Application No: EP/143/21/CLP

Site Address: 2 Hillview Crescent East Preston BN16 1RD

Description of works: Lawful development certificate for a proposed rear dormer, insertion of front roof window and confirmation that following grant of EP/41/18/PDH confirmation of completion by 30th May 2019 is no longer required.

Thank you for your internet representation made on 2nd December 2021 which has been recorded as an objection with the comments as follows:

Proposed Elevations
and Sections

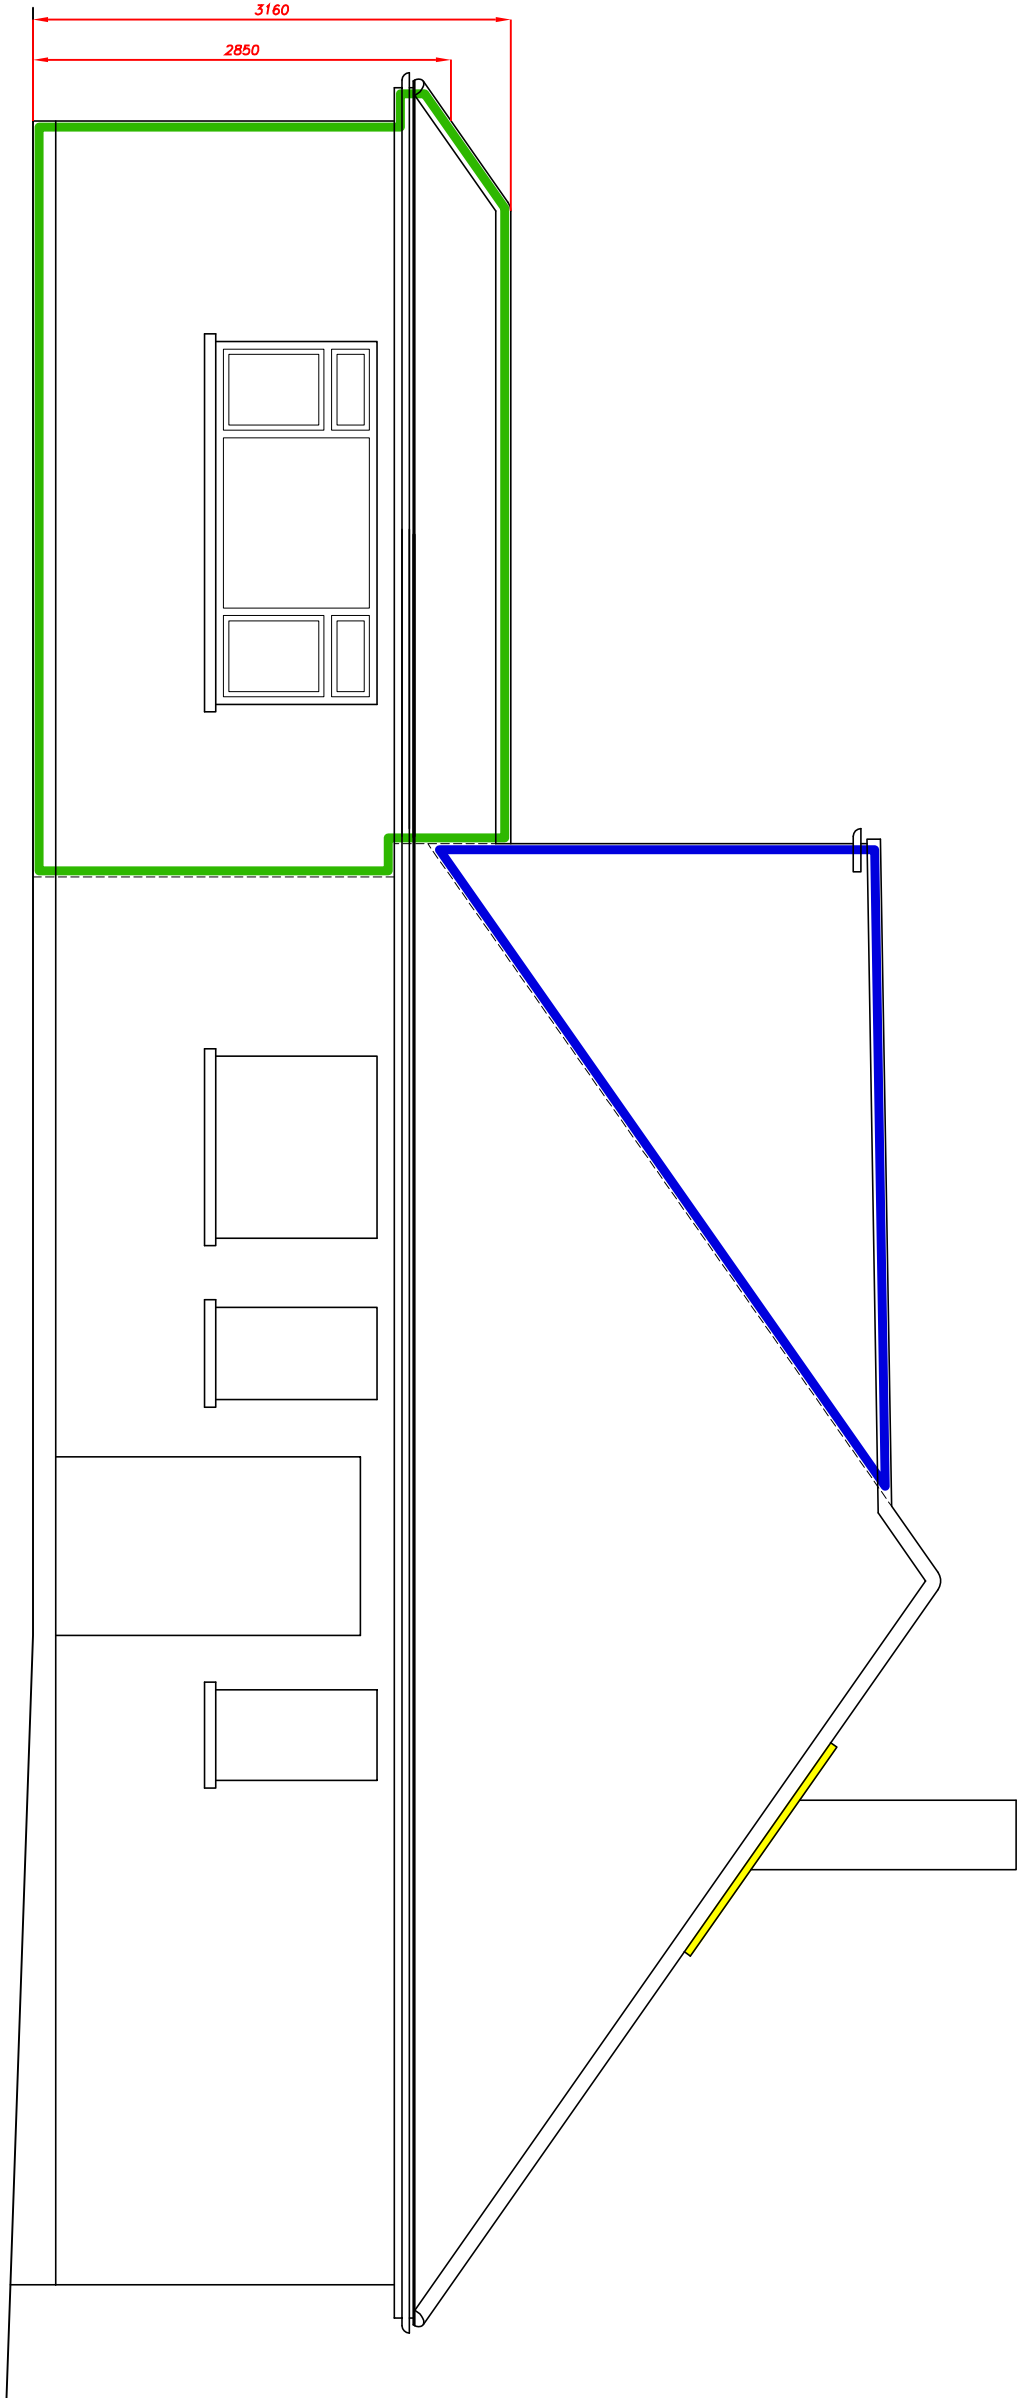
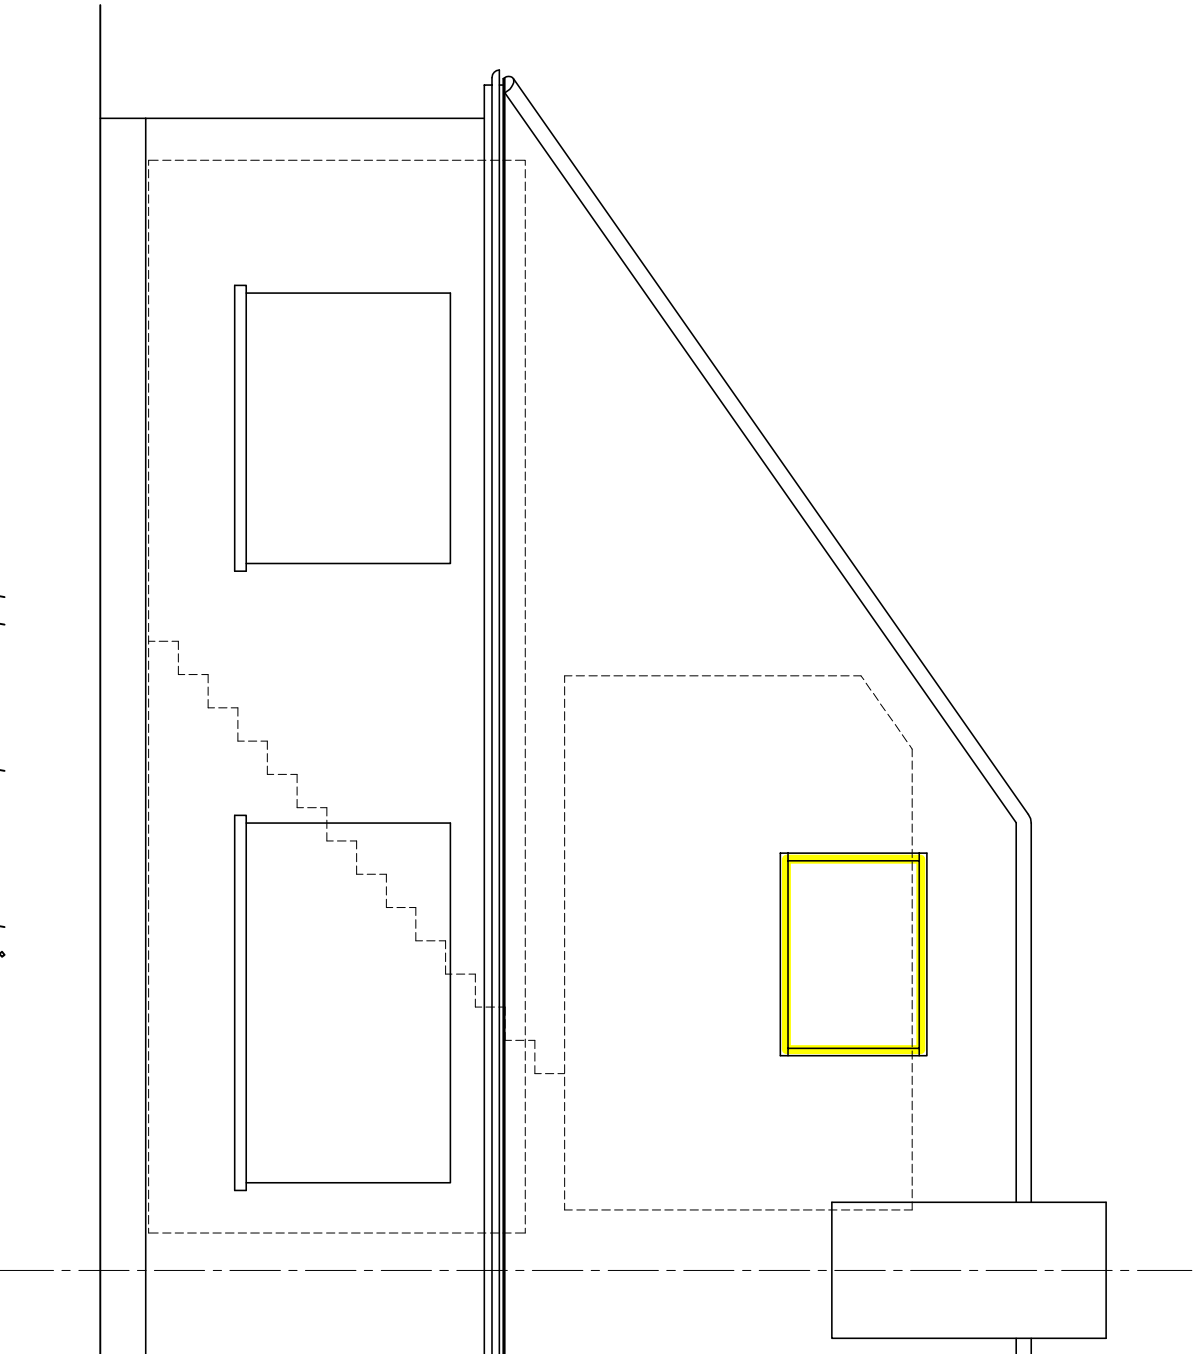
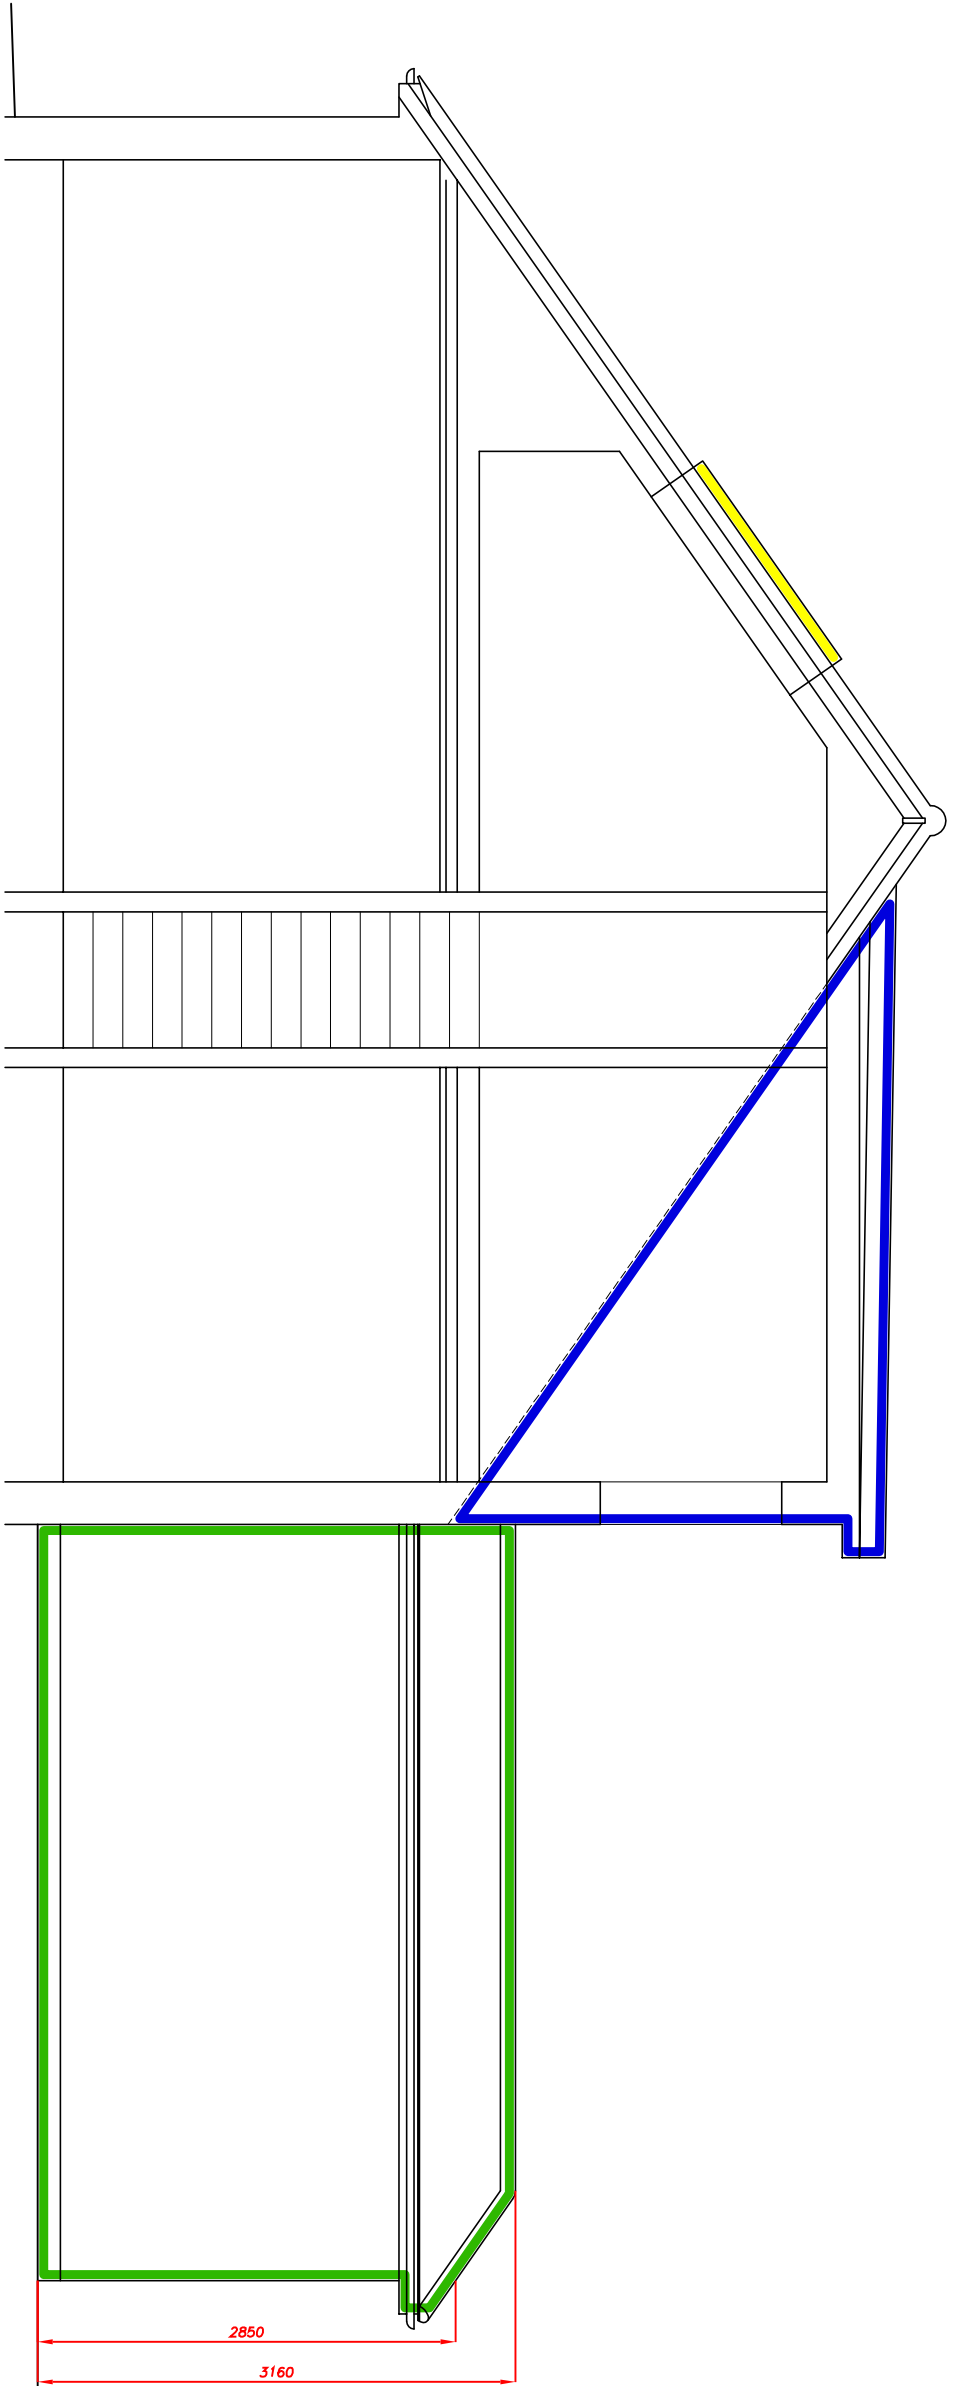
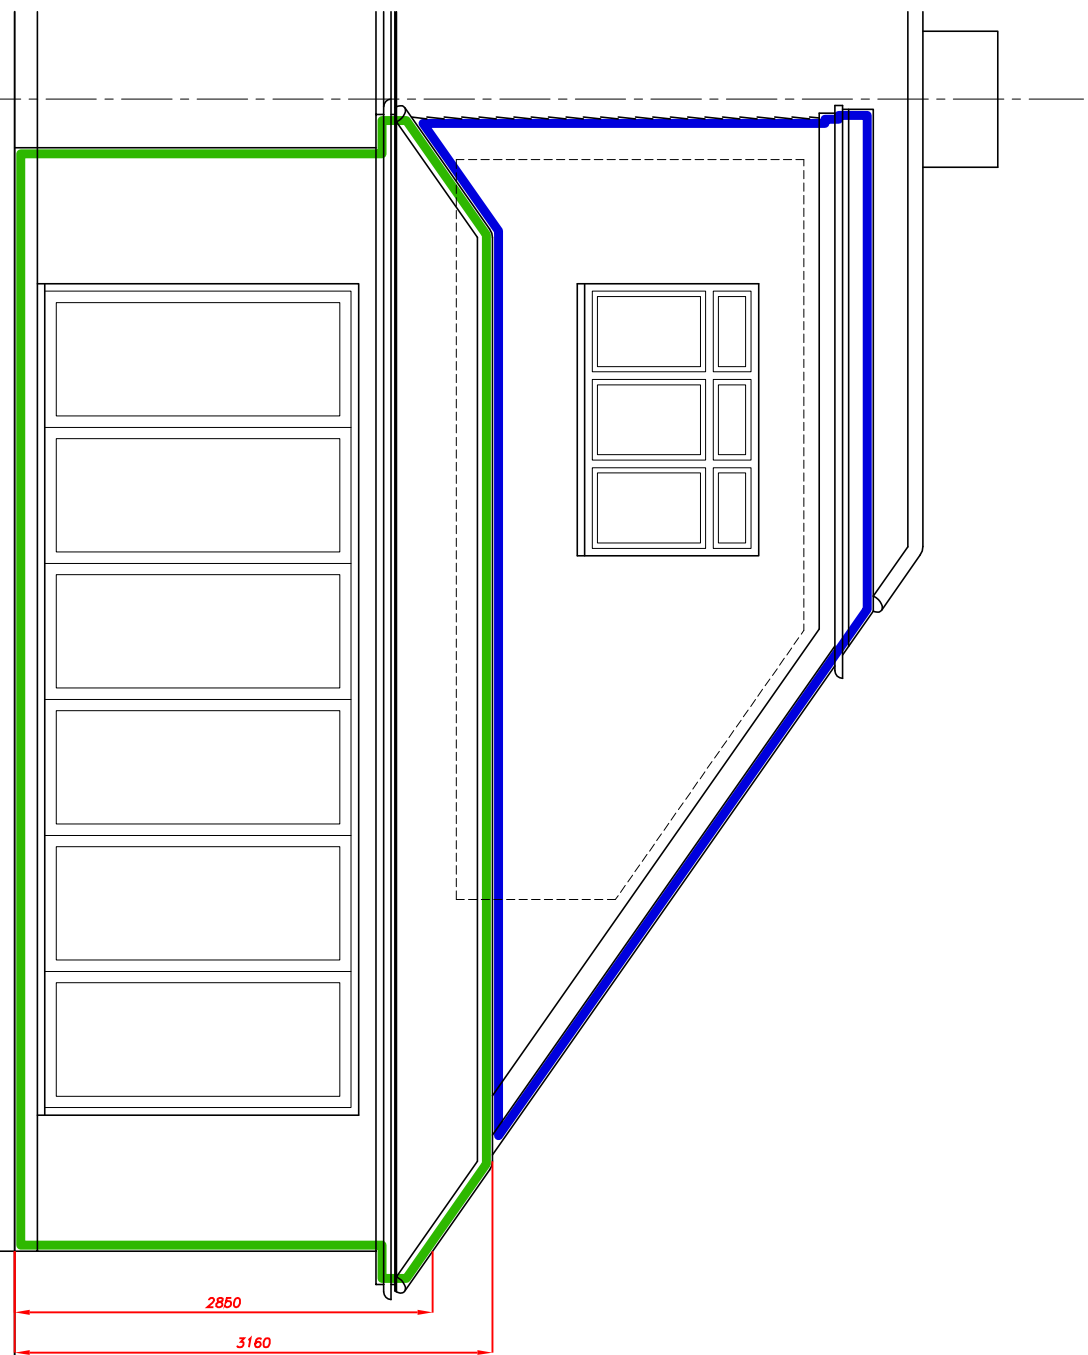
I write as Chairman of the East Preston and Kingston Preservation Society to express our concern at this request for a Lawful Development Certificate for a dormer. The drawings provided are not easy to interpret, as the design appears awkwardly squeezed. The planes of the roof on the western elevation are especially hard to envisage. Another question is that the plans now submitted for EP/143/21/CLP do not appear to agree with those submitted with the allowed EP/41/18/PDH application, given that the small rear wing now existing at the north on the western side, instead of being preserved, with the extension under that grant being partly an infill, would seem to be being demolished - or at least a substantial part of the roof being removed - as a result of this application for a Lawful Development Certificate. Does this not merit a full planning application?
